Review Comments

Chase Bank- Indian School Road

6670 Indian School Road NE

Traffic Circulation Layout

TRAFFIC CIRCULATION PLAN

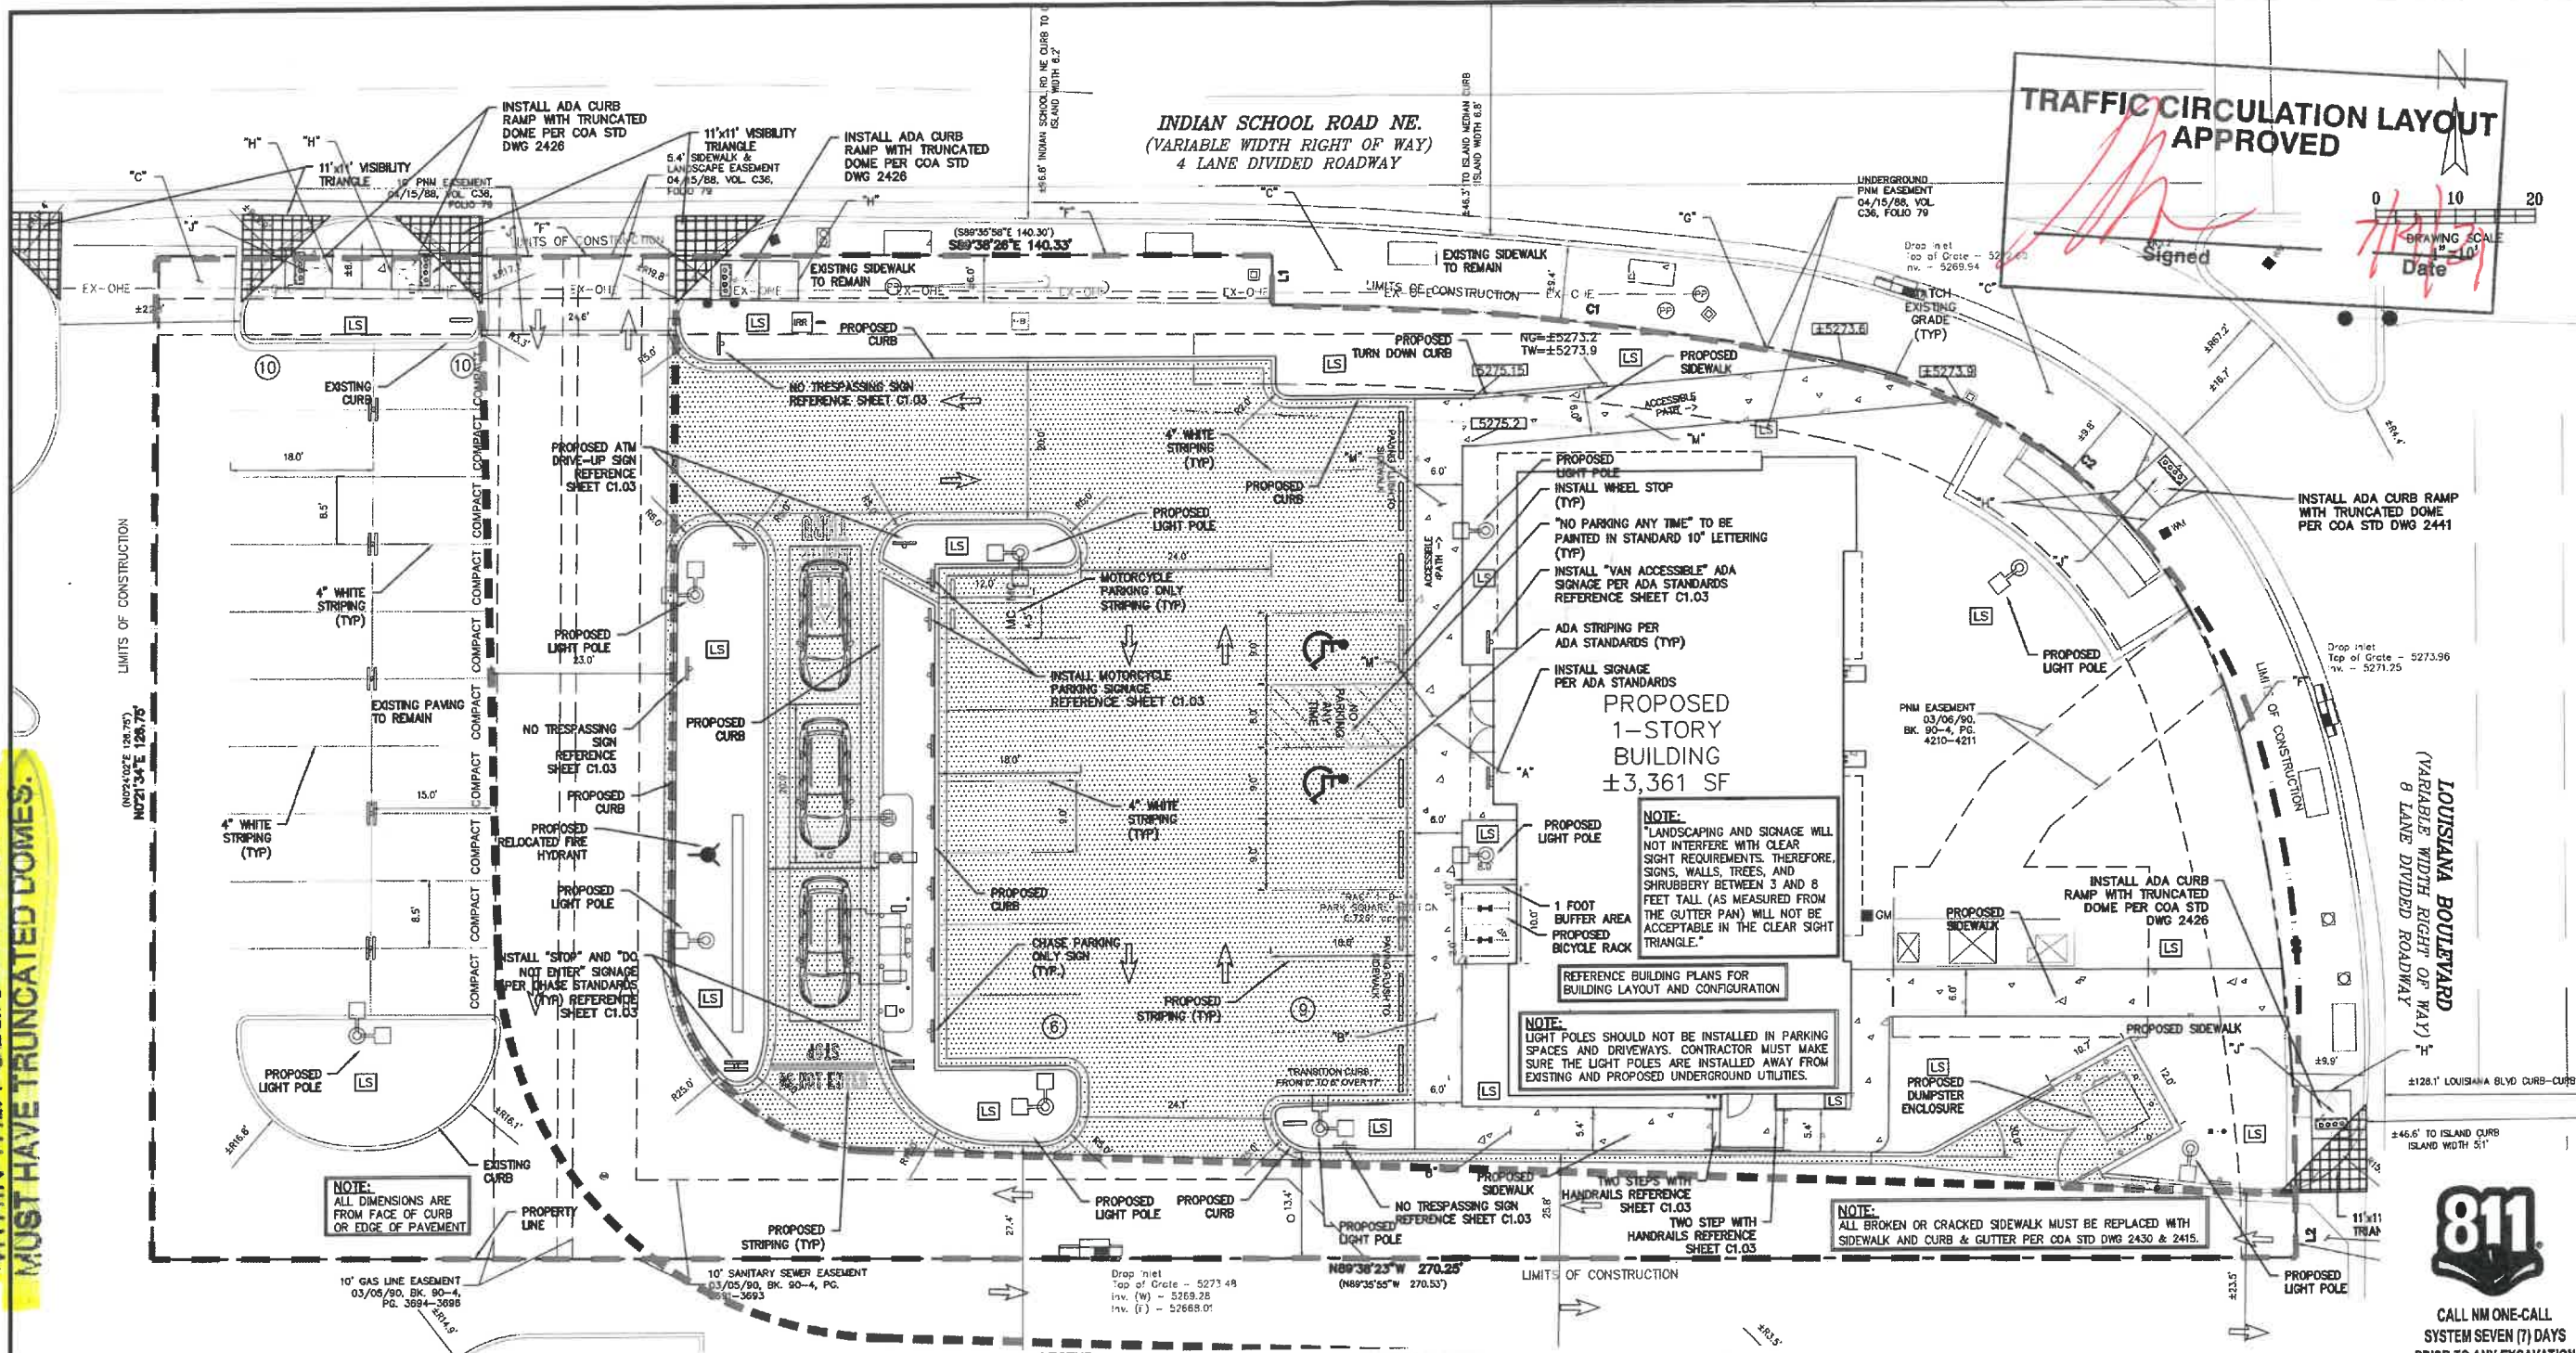
Response: Approved stamped, Solid Waste Site plan enclosed.
3. The new location of the Solid Waste enclosure appears to impact 3 parking stalls that have been removed. Please provide a new parking stall calculation to substantiate the loss of the stall wouldn't impact the total required stall and/or provide a statement as to this concern.

4. Add a note stating "All broken or cracked sidewalk must be replaced with sidewalk and curb & gutter." A build note must be provided referring to the appropriate City Standard drawing.

Response: Under existing condition the leased are encompasses 32 parking spaces. Under proposed conditions, the amount of parking spaces increased to a total of 35 spaces. There is a net increase of 3 parking spaces from existing conditions, providing additional onsite parking.

Response: Note added. Reference lower area near the dumpster enclosure.
5. Please provide a letter of response for all comments given.
Response: Response letter enclosed.
